Defence Infrastructure Organisation

Application Ref: EN010125

EN010125: Application by RWE Renewables UK Dogger Bank South (West) Limited and RWE Renewables UK Dogger Bank South (East) Limited for the Dogger Bank South Offshore Wind Farm Project

Examining Authority's (ExA) Written Questions – ExQ1.

Figure: 15-2      Drawing No: PC2340-RHD-OF-ZZ-DR-Z-0697

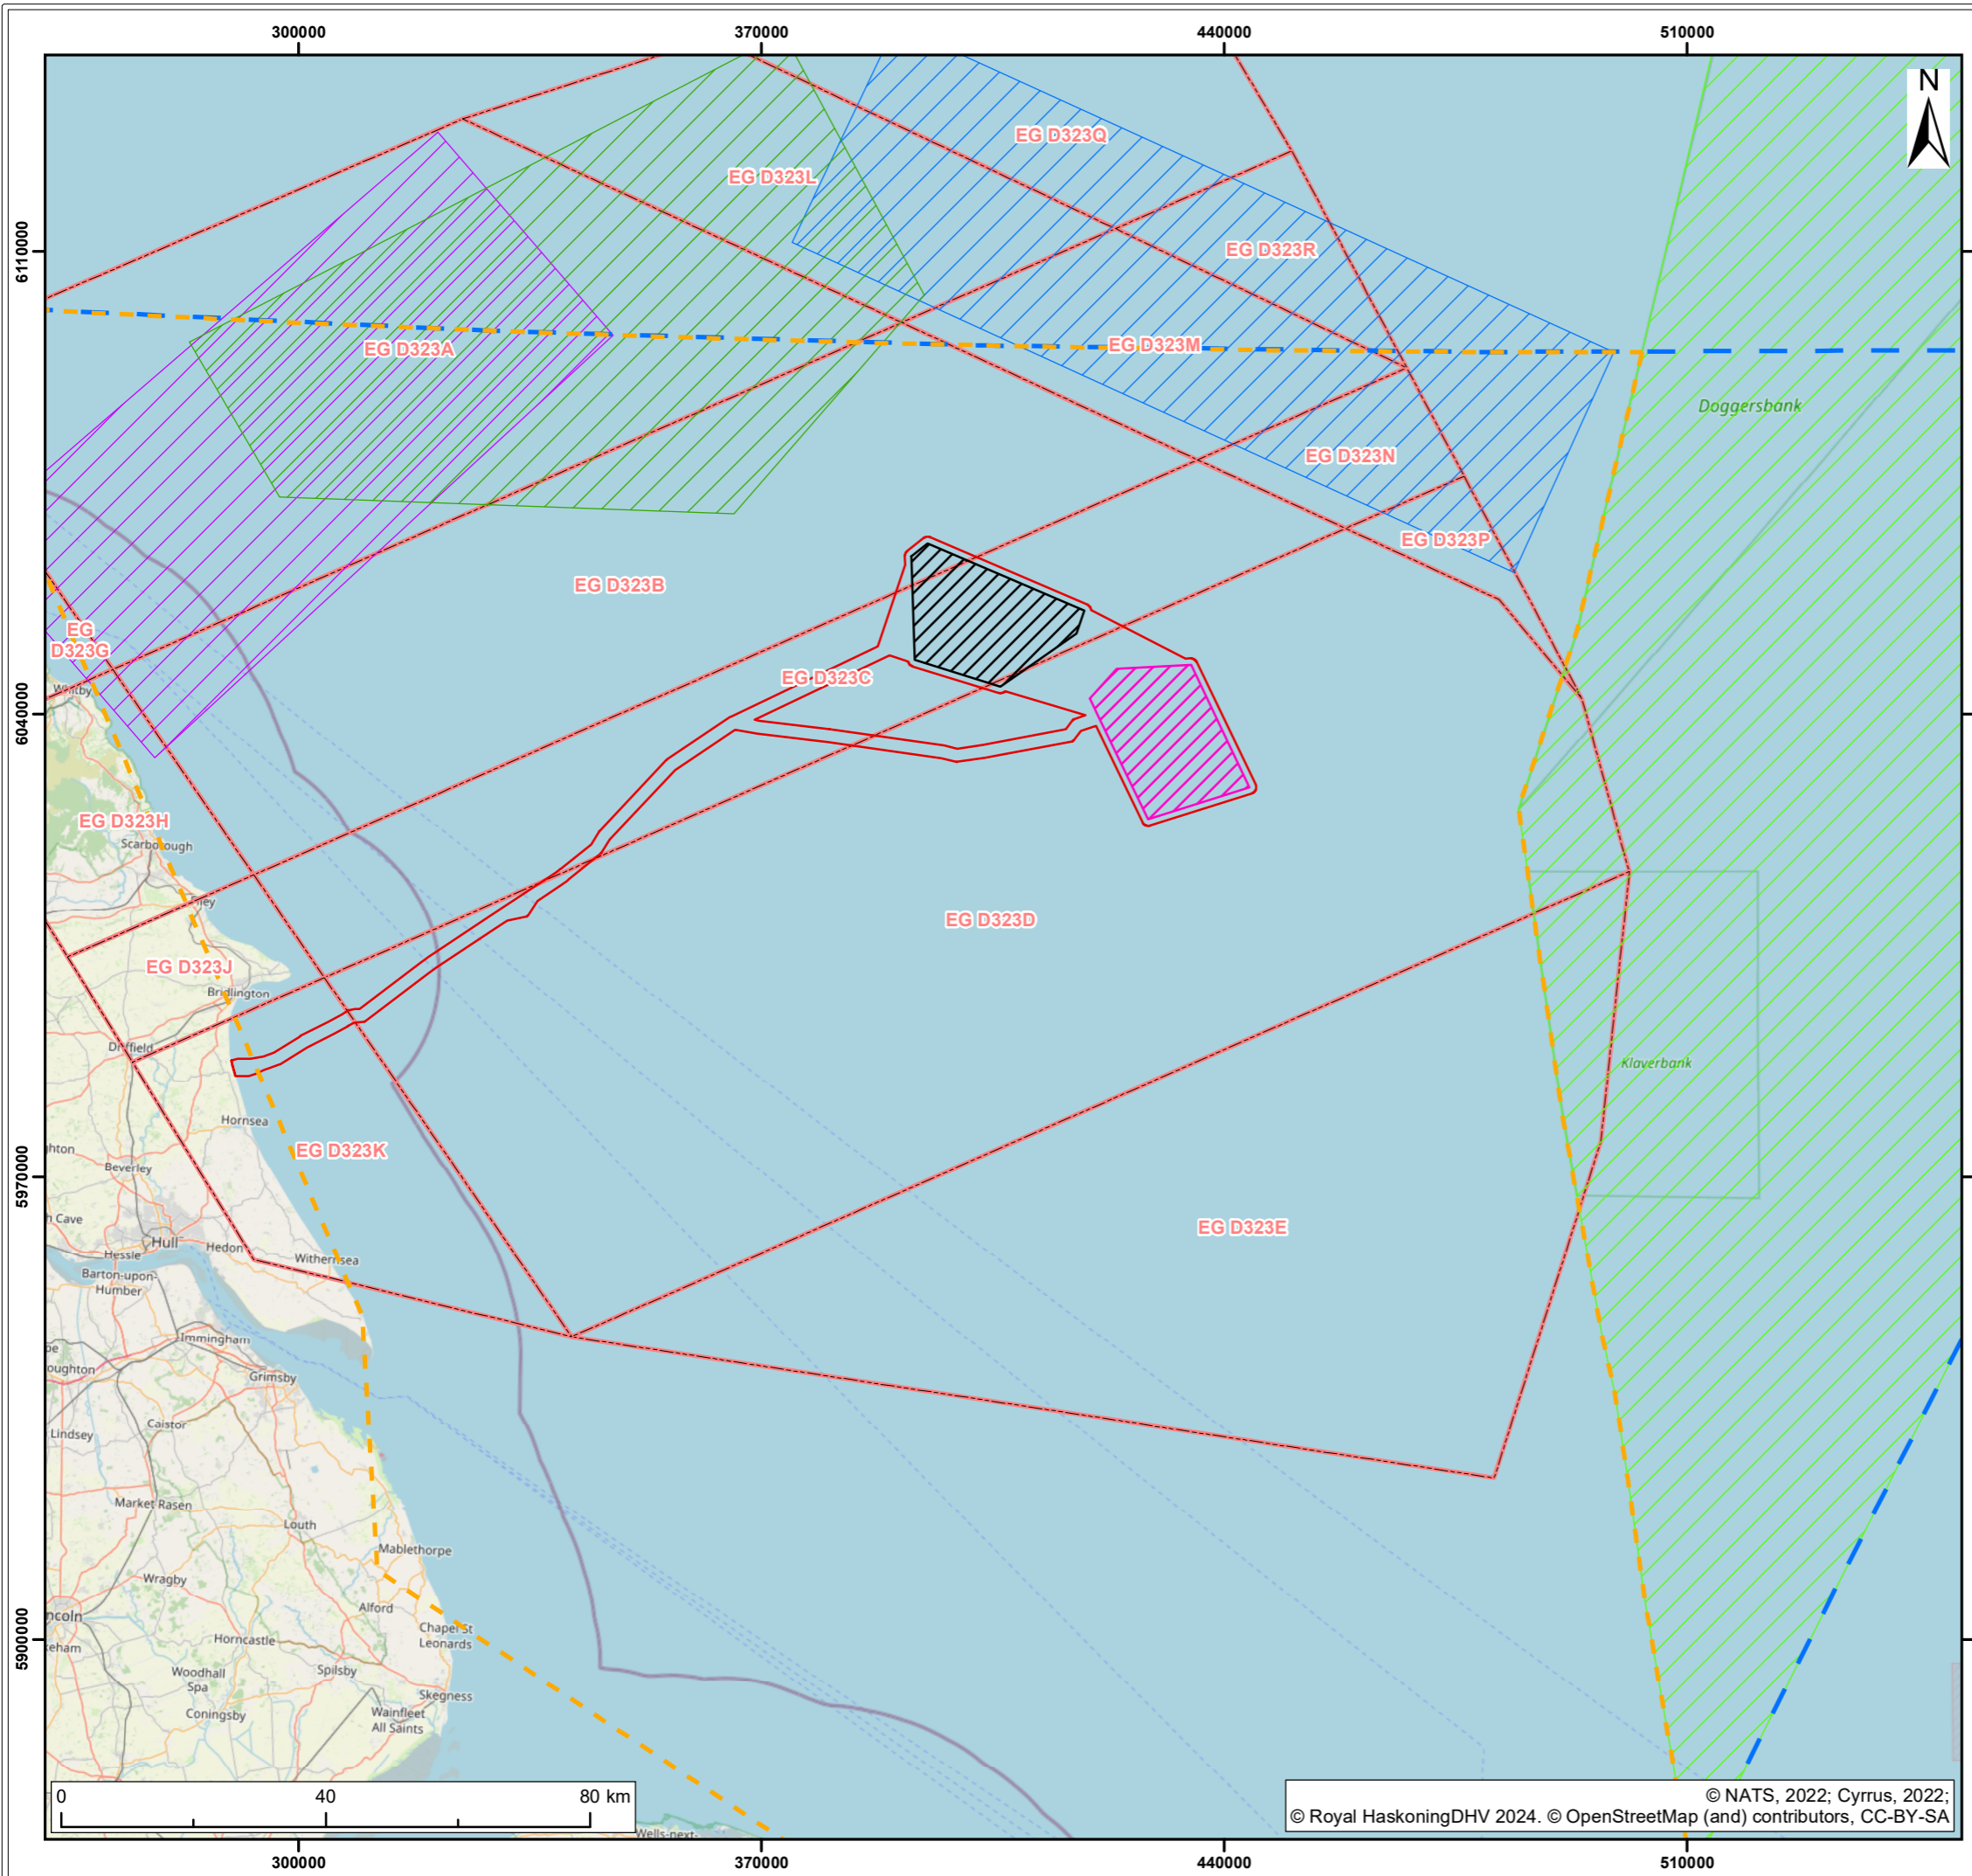
In your Relevant Representation [AS-002], you explain the Proposed Development is within Low Flying Area 11. In addition, the Proposed Development is identified within the Southern Managed Danger Areas [APP-125, section 15.5.3] and [APP-126, Figure 15-2]. To aid the ExA in considering compliance with NPS EN-1 paragraph 5.5.59, can you confirm whether the Proposed Development would unacceptably limit military training, in isolation and cumulatively with other projects, including low flying aircraft operations.

The generation assets proposed would be located below a Danger Area complex designated EG D323. The EG D323 designation applies between flight level 05 (approximately 5000ft) and flight level 66 (approximately 66000ft). The development proposed would not be considered to have any significant impact on the operation or capability of that designated airspace, as such the MOD has offered no objection on this ground.
